<b>Consultation Response from KC, Lead Local Flood Authority</b>
<b>2024/91007 adj, 208, Yew Tree Road, Birchcliffe, Huddersfield, HD2 2EQ</b>
<b>Discharge of conditions 6 (Phase II report), 7 (Remediation Strategy), 10 (affordable housing), 11 (public open space), 12 (education), 13 (sustainable transport), 14 (temporary drainage), 16 (drainage scheme), 17 (attenuation and discharge rate), 18 (access point), 19 (estate roads), 21 (footway details), 23 (construction management plan), 24 (noise report), 25 (ecological design strategy) and 26 (electric vehicle charging) of previous permission 2018/90151 for outline application for erection of residential development</b>
<b>Date Responded: 14<sup>th</sup> April 2025 Responding Officer: Paul Farndale Responding Ref:</b>

### **Conditions 16 & 17 – Drainage Details and Attenuation**

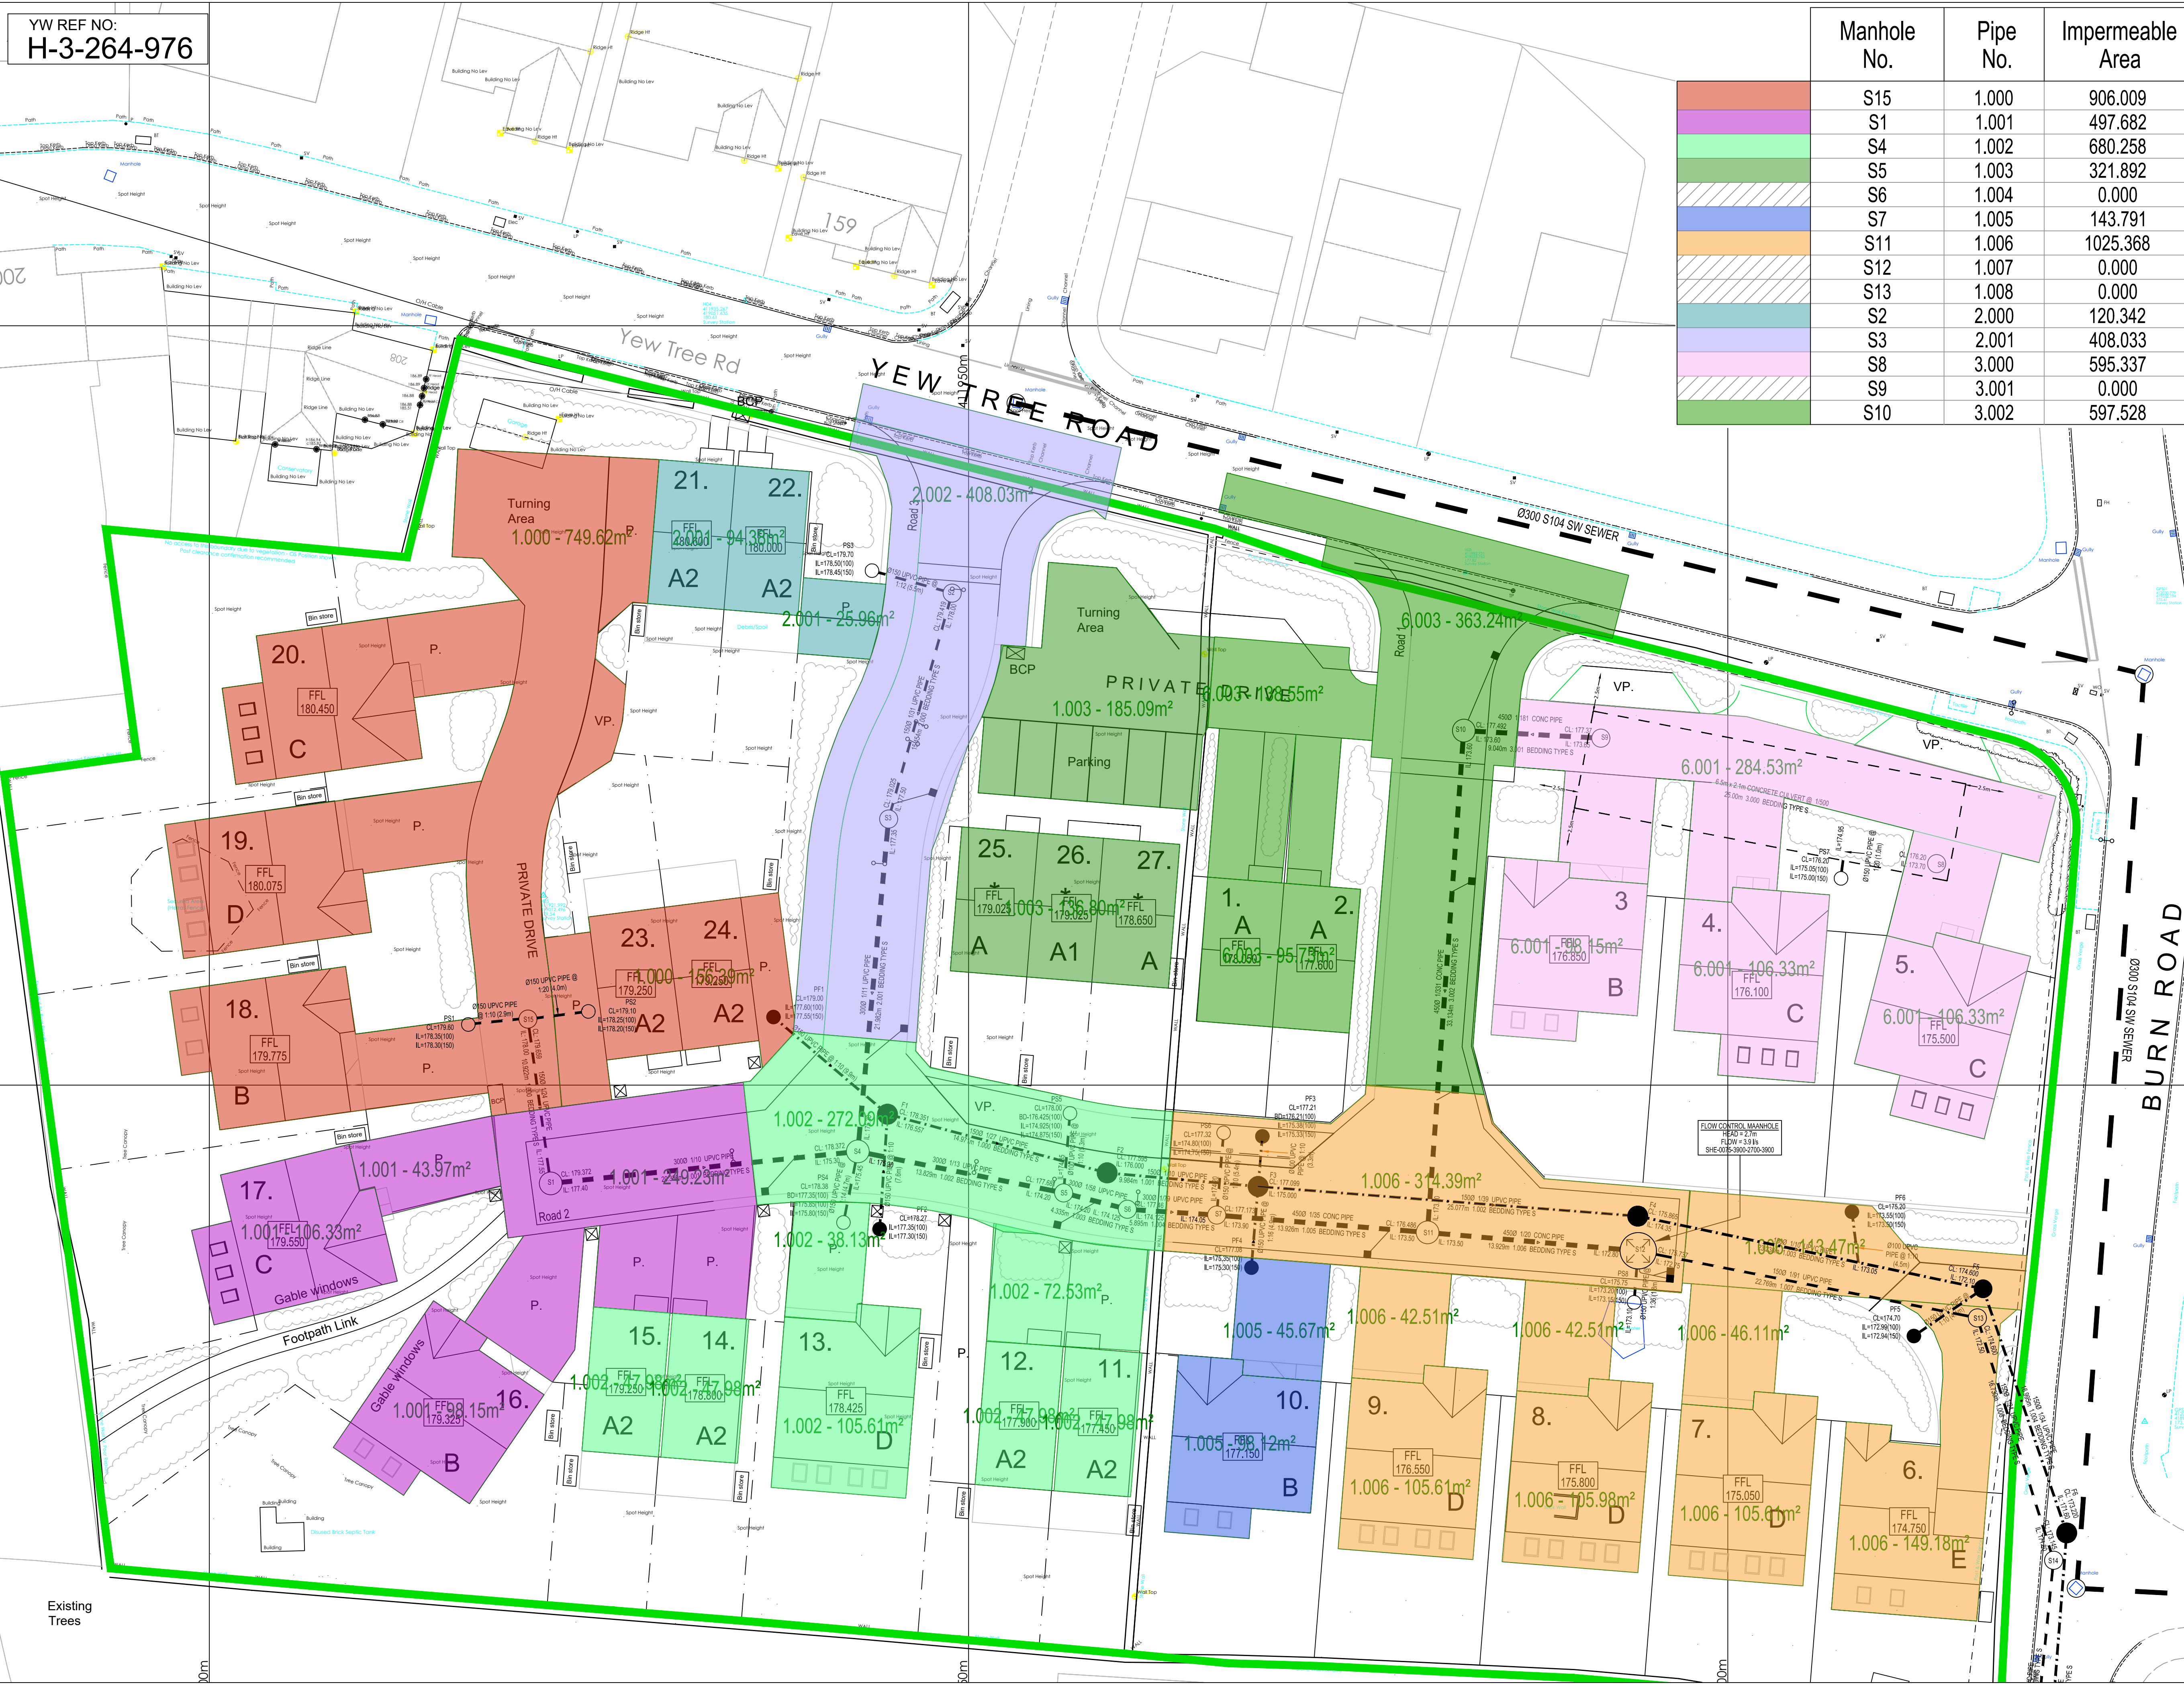
The latest impermeable area drawings now correspond to drainage drawings with particular reference to plots 11 and 12.

The applicant should show that all comply with hydraulic simulations.

Please ensure that both drainage drawings and modelling simulations correspond.
